AMA Designer's Response

Site Location – Northorpe Lane, Mirfield

17th June 2021

The proposals have now been subject to a Stage 1 Road Safety Audit (RSA1) carried out by Jonathan Birkett of Meraki Alliance on Monday 14th June 2021. The 'Problems' and Recommendations' from that RSA1 are included in this Designer's Response report for ease of reference.

Drawing:
**KIRKLEES REFUSE VEHICLE
SWEEP PATH ANALYSIS**

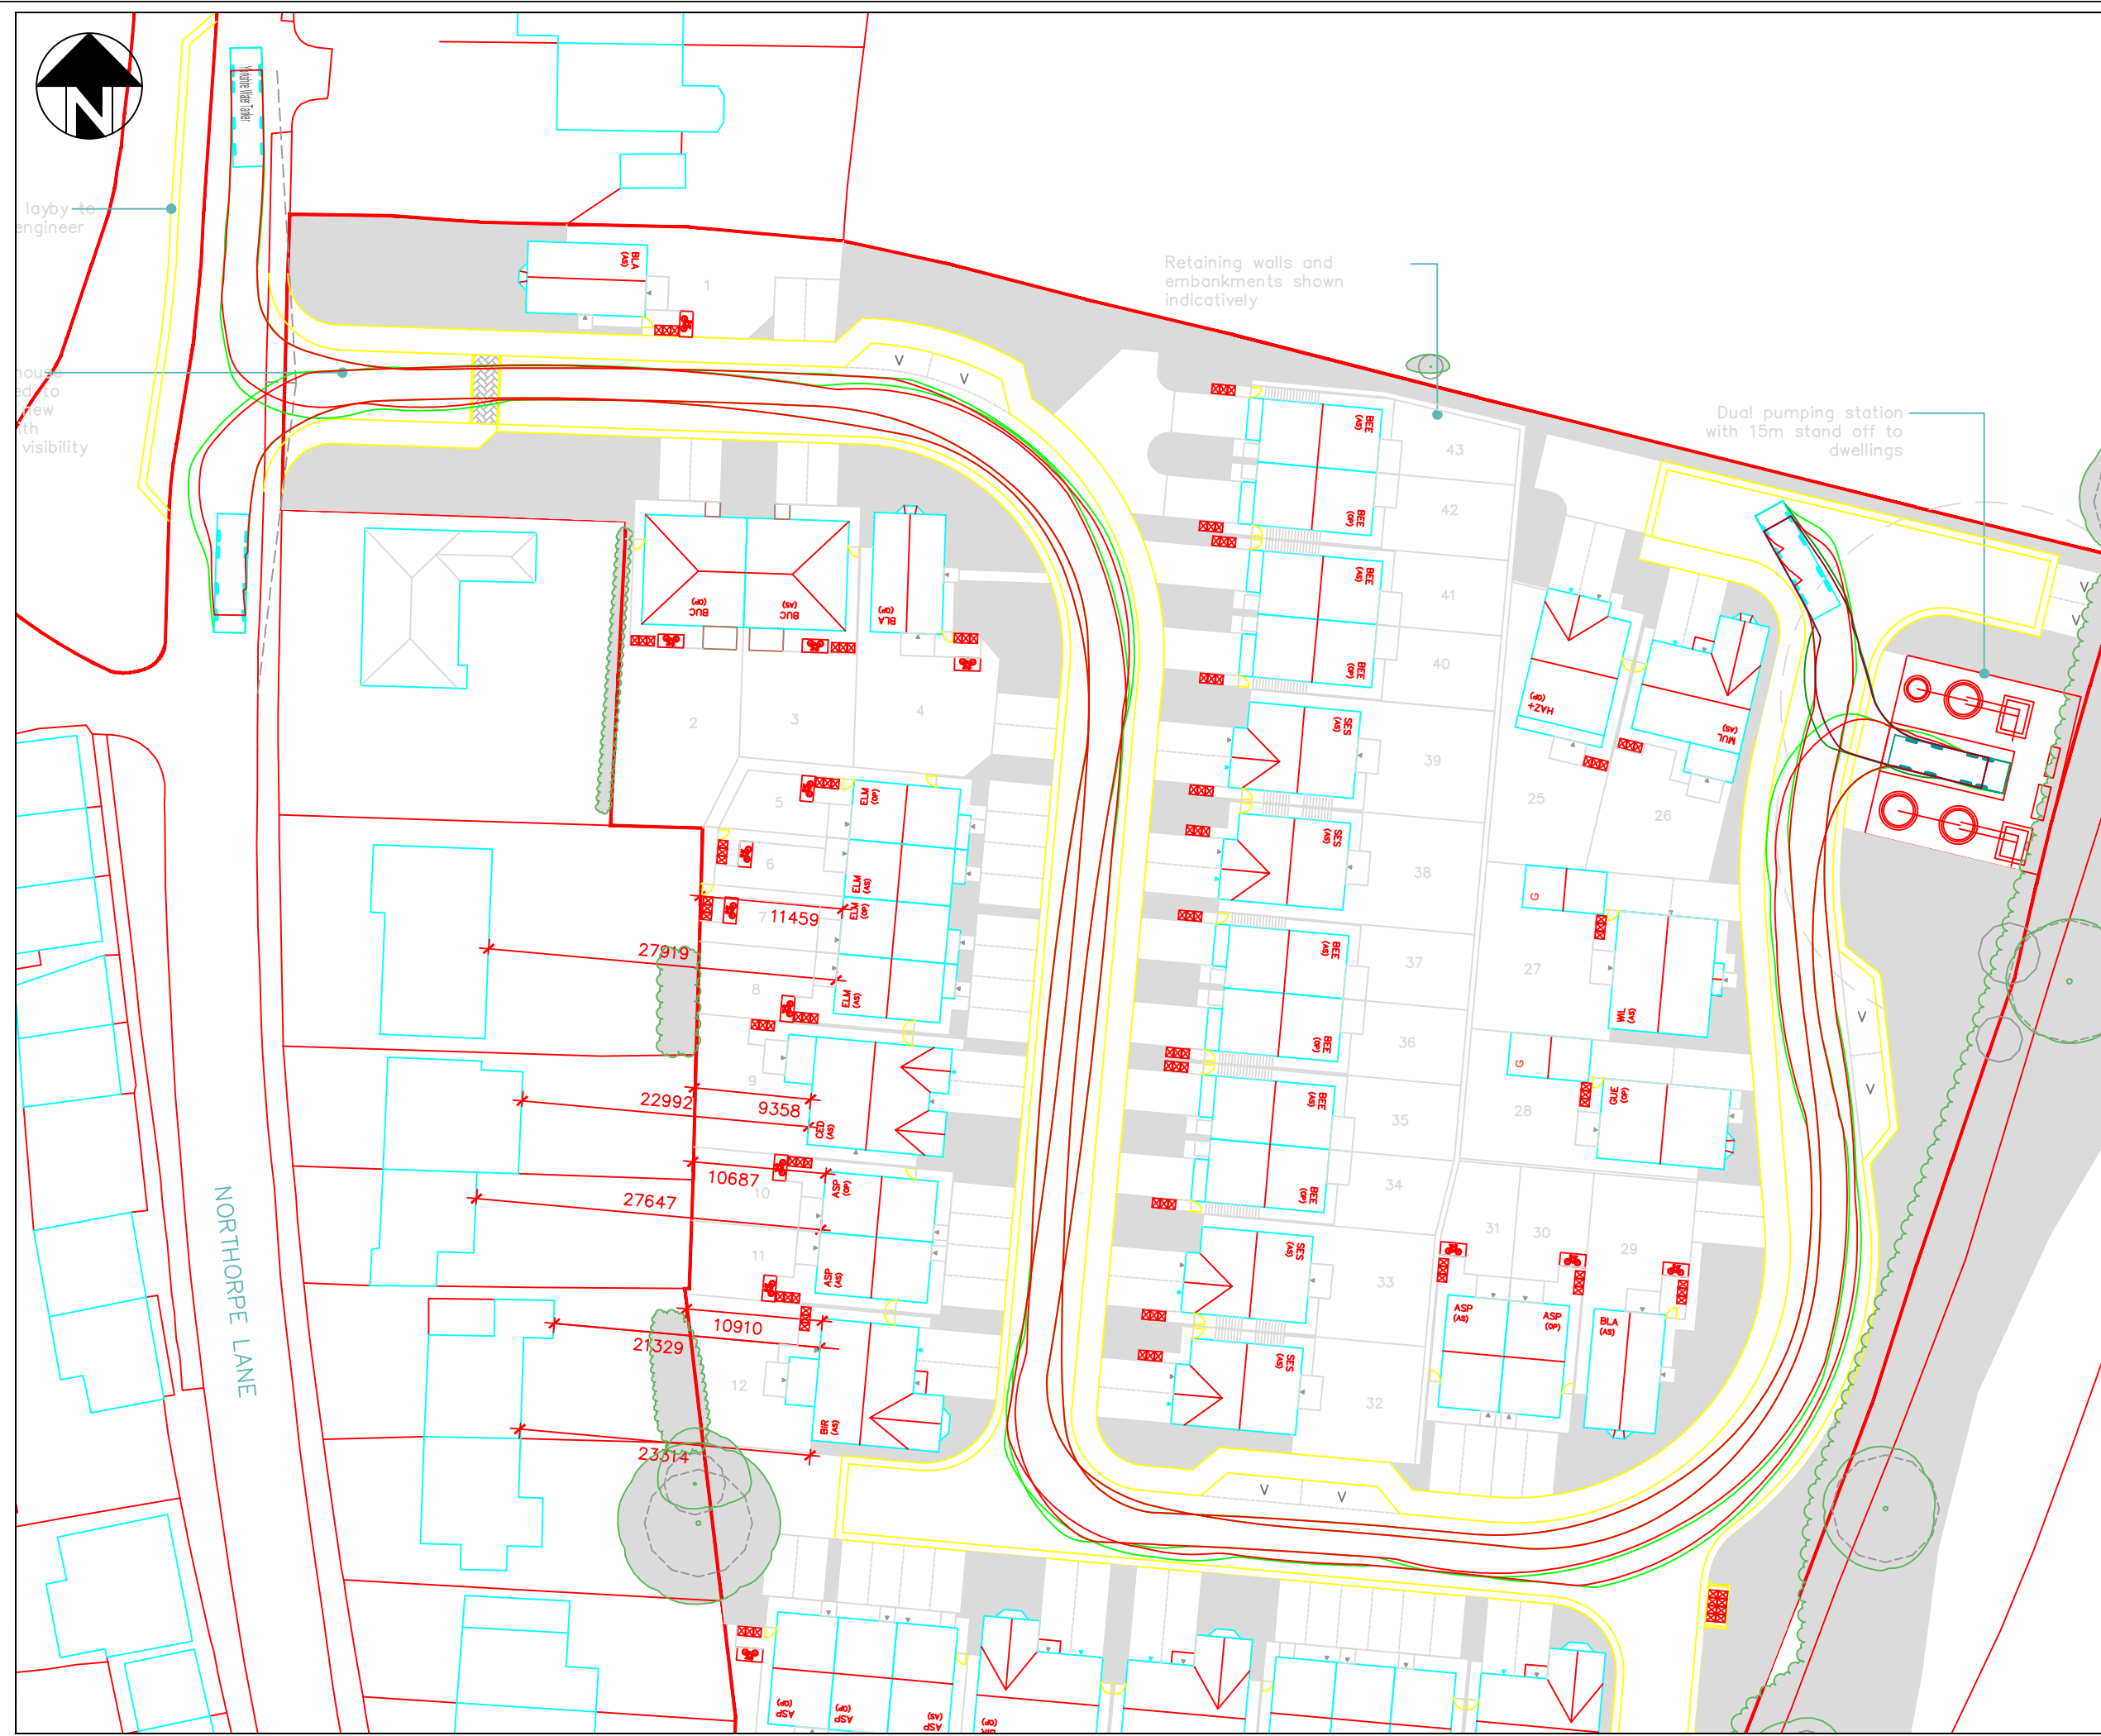
Problem 4: *Details of vehicle tracked movements are not provided on the drawings. Inappropriate carriageway widths and turning radii can result in increased vehicle collisions as well as pedestrian-vehicle collisions.*

Summary: *Details of the swept paths of vehicles, are not provided on the drawings. Inappropriate carriageway widths and junction radii can result in vehicles failing to safely negotiate the new junction arrangement increasing the risk of vehicle collisions and pedestrian-vehicle collisions.*

Provide swept path movements the new site access.

Vehicle tracking will be undertaken as part of the detailed design to ensure the road layout is safe and functional.
